**RE: NON-MATERIAL AMENDMENT APPLICATION TO APPROVAL REF:
BE/113/17/RES FOR THE REPLACEMENT OF THE SUBSTATION WITH A GARAGE
AND ASSOCIATED AMENDMENTS TO LANDSCAPING**

On behalf of our client, Linden Homes South, I am pleased to enclose a Non-Material Amendment application under Section 96A of the Town and Country Planning Act 1990 (as amended) for amendments to the scheme approved under application reference BE/113/17/RES at the site Land west of New Barn Lane, North Bersted.

scheme: Land West of New Barn  
Lane, North Bersted  
client: Linden Homes  
drawing: Landscape Proposals  
date: July 2017  
scale: 1:200@A1  
drawing no: LIN21257 12D Sheet 2  
drawn: LS checked: AE

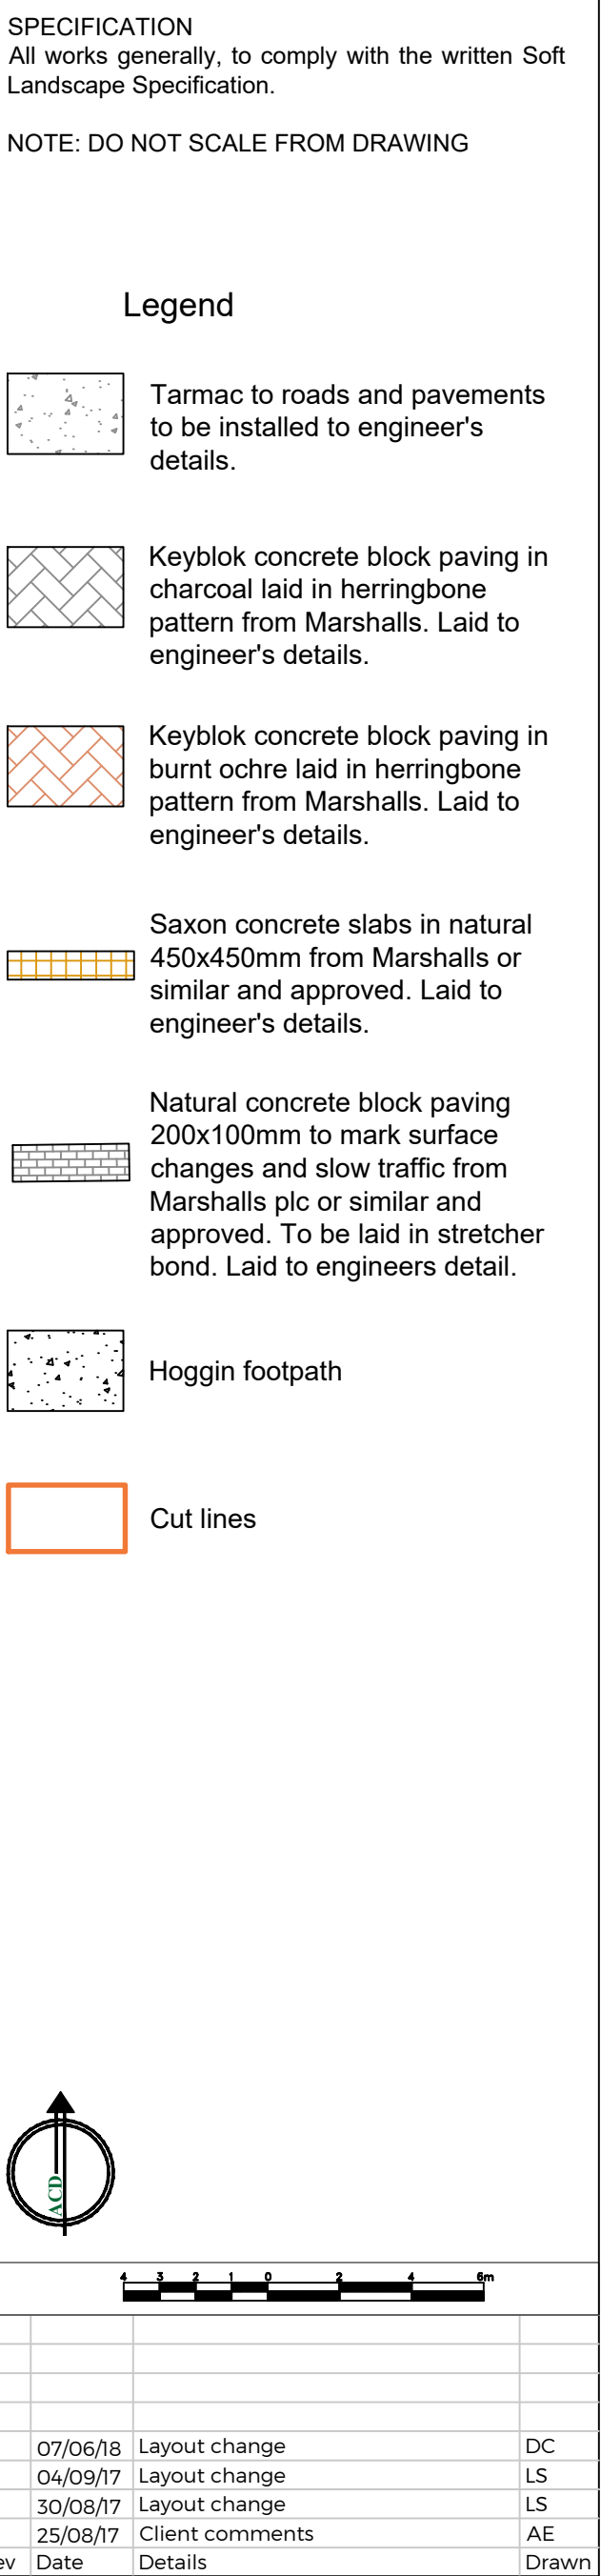
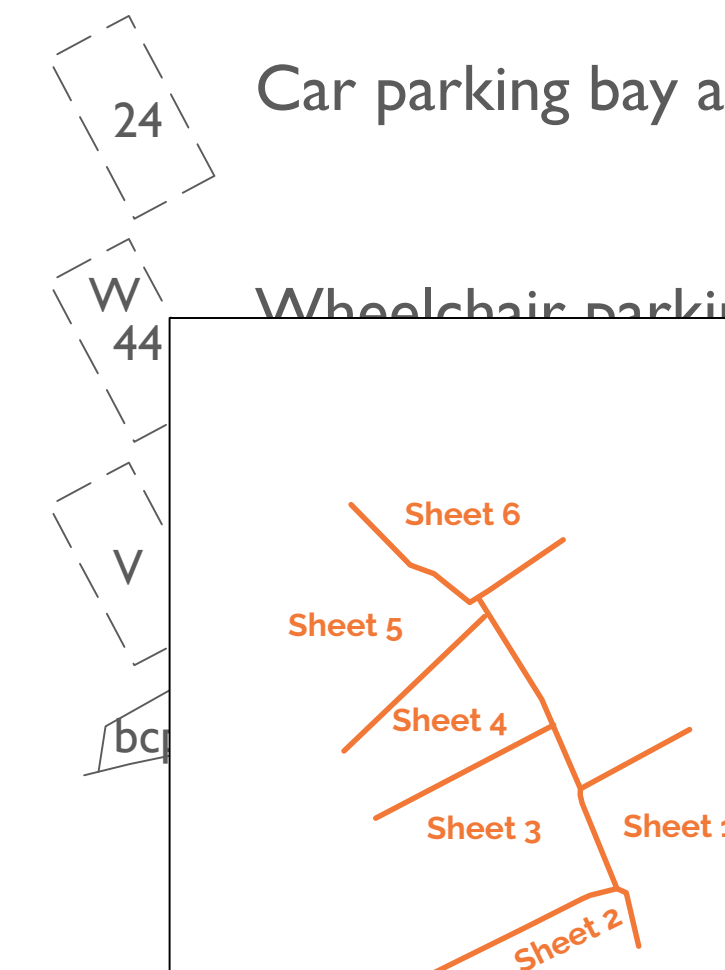
- Replacement of the substation adjacent to Plot 9 with a double garage to serve Plot 9
- Removal of hardstanding parking spaces to the side of Plot 9 and re-landscaping.
